Appeal Decision

Appeal Ref: APP/Z4718/W/24/3355773

1 Edward Latham House, Oates Street, Dewsbury, Kirklees WF13 1BB

- The appeal is made under section 78 of the Town and Country Planning Act 1990 (as amended) against a refusal to grant planning permission.
 - The appeal is made by Mr A Cheema (FC Property Limited) against the decision of Kirklees Council.
 - The application Ref is 2024/62/90107/E.
 - The development proposed is the erection of extension and re-building of derelict buildings to form flats (within a Conservation Area).
-

PROPOSED FIRST FLOOR PLAN
SCALE - 1:100

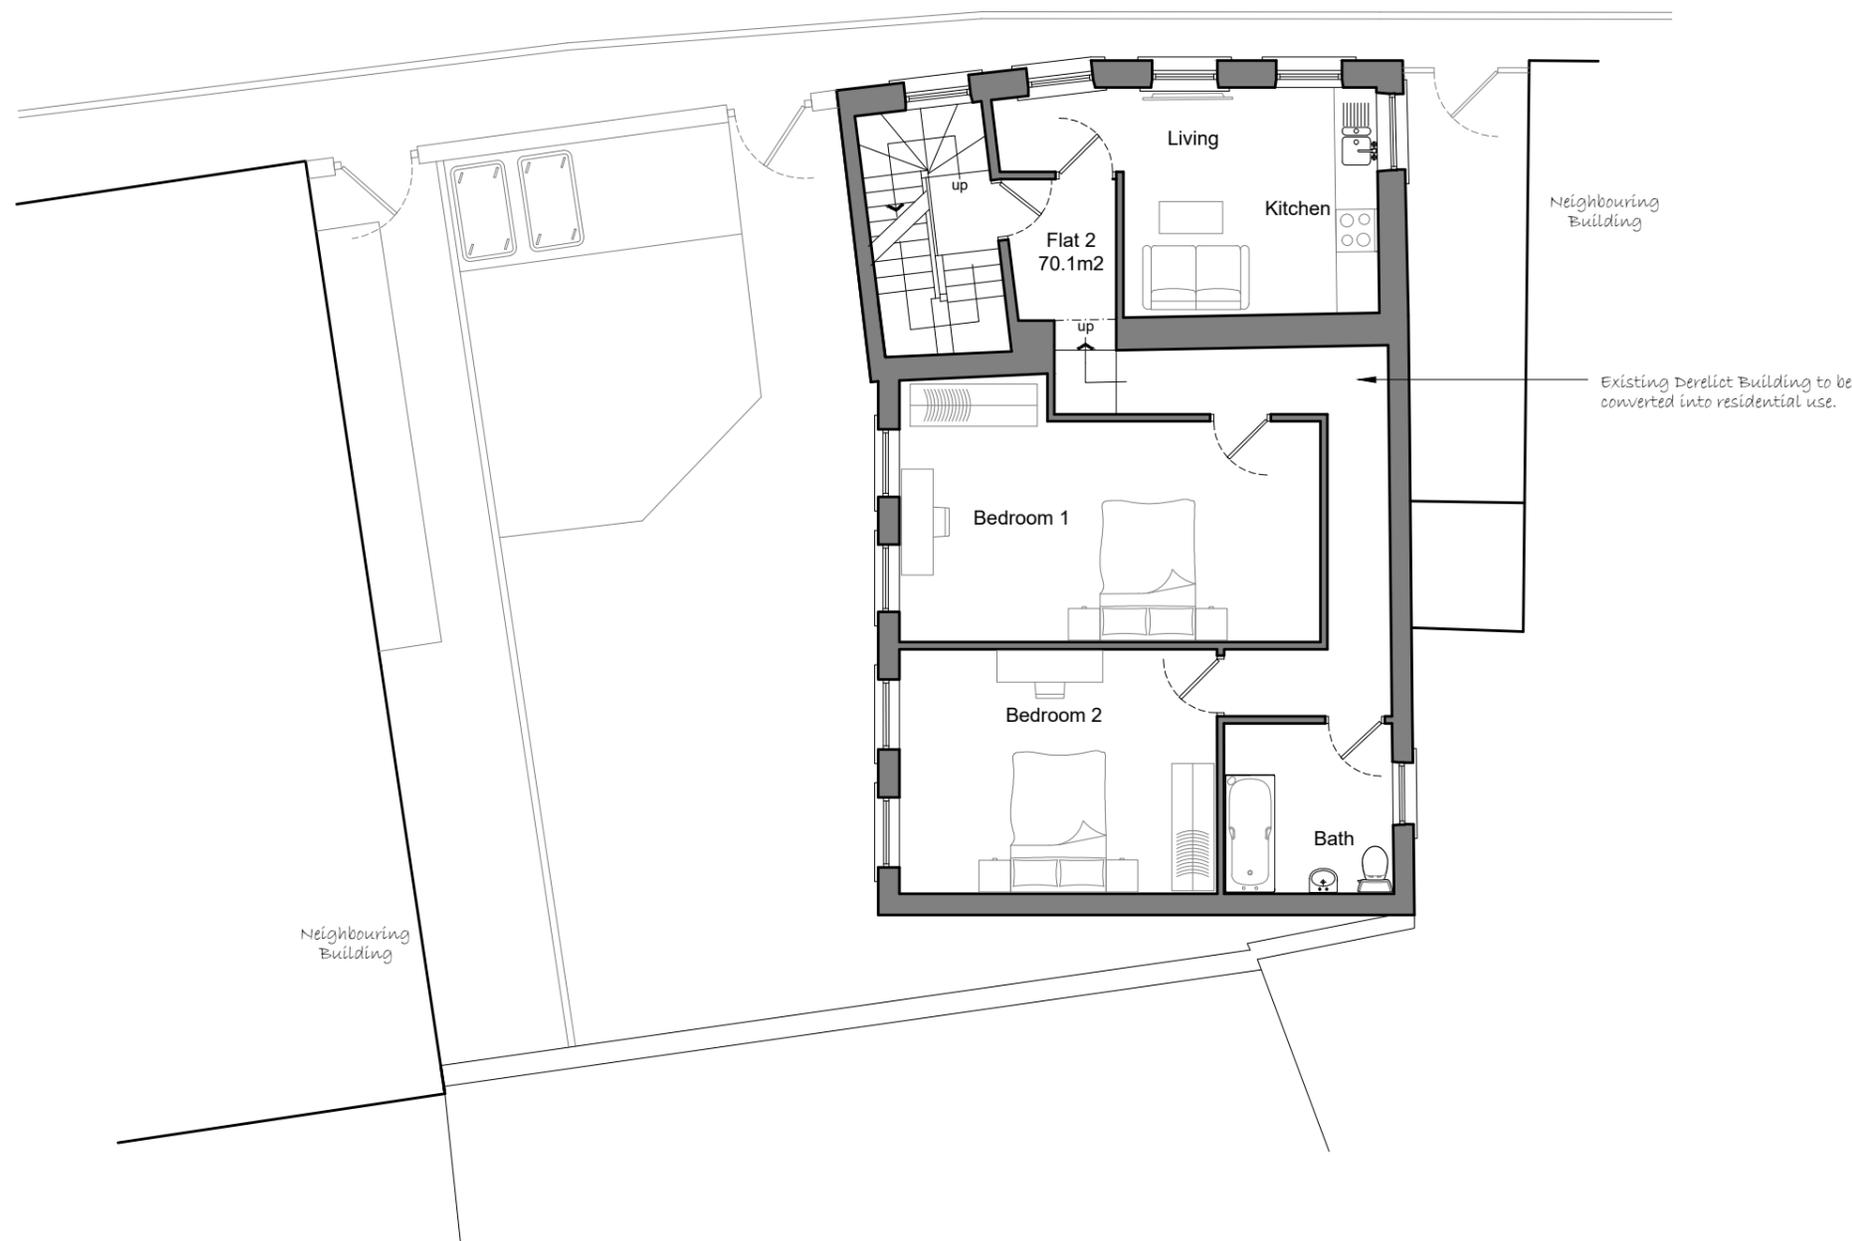
4. The proposed scheme would provide one flat on each of its three floors. This includes a number of windows on the side elevation to the yard area, immediately beyond which is the two-storey elevation of the neighbouring building. Whilst the yard area will be landscaped, the close proximity and scale of this neighbouring building would limit outlook for future occupants, particularly as the elevated positioning of the neighbouring buildings to the west on Grove Street would create an enclosing effect on future occupiers of these side facing rooms. These factors would also limit the amount of natural light reaching the bedroom areas.

5. Although the windows to the side yard area would serve bedrooms, they are nevertheless habitable spaces even if future occupants are unlikely to spend all their time in the respective bedrooms and that each of the living rooms would be provided with sufficient light and adequate outlook. I recognise that paragraph 130 c) of the National Planning Policy Framework (Framework) does advocate a flexible approach in applying policies and guidance relating to daylight and sunlight, but it does also set out the resulting scheme would need to provide acceptable living standards.

PROPOSED SIDE ELEVATION (NORTH)
SCALE - 1:100

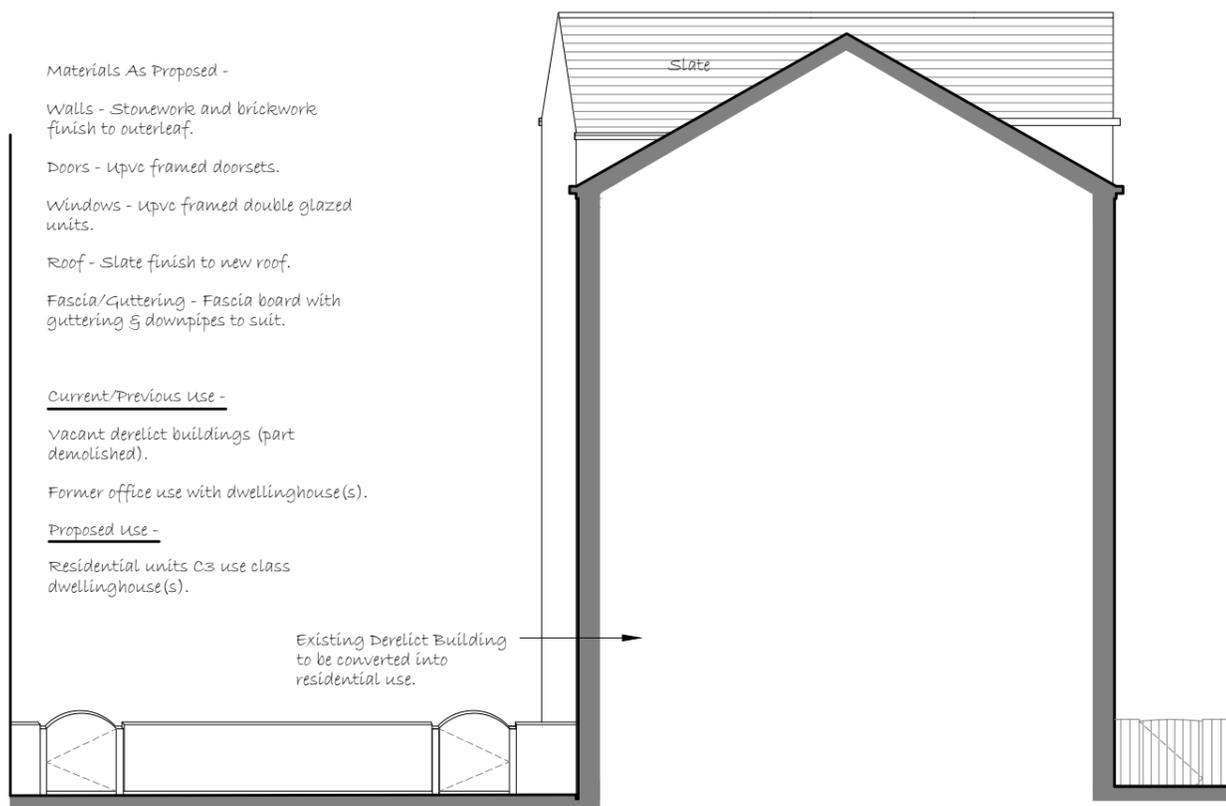
6. The Council has also raised overlooking concerns that would arise as the neighbouring building beyond the yard has a number of windows on its southern

elevation that would face the proposed bedroom windows. Although the separation distance would only be around 6.5m-7.5m, the appellant has indicated that the neighbouring building at 9 Oates Street has a storage/warehouse use and my observations at the site visit also indicated that this neighbouring property is not in residential use. As such, and despite the close relationship, I do not consider that harmful overlooking would arise.

7. Nevertheless, I conclude for the reasons set out above that the development proposed would not provide satisfactory accommodation for its future occupiers, having regard to outlook and light. Accordingly, it would conflict with Policy LP24 of the Kirklees Local Plan Strategy and Policies, which seeks, amongst other matters, a high standard of amenity for future occupiers. It would also be contrary to Paragraph 135 of the Framework and the Housebuilders Design Guide SPD, which seek to ensure a high standard of amenity for existing and future users.
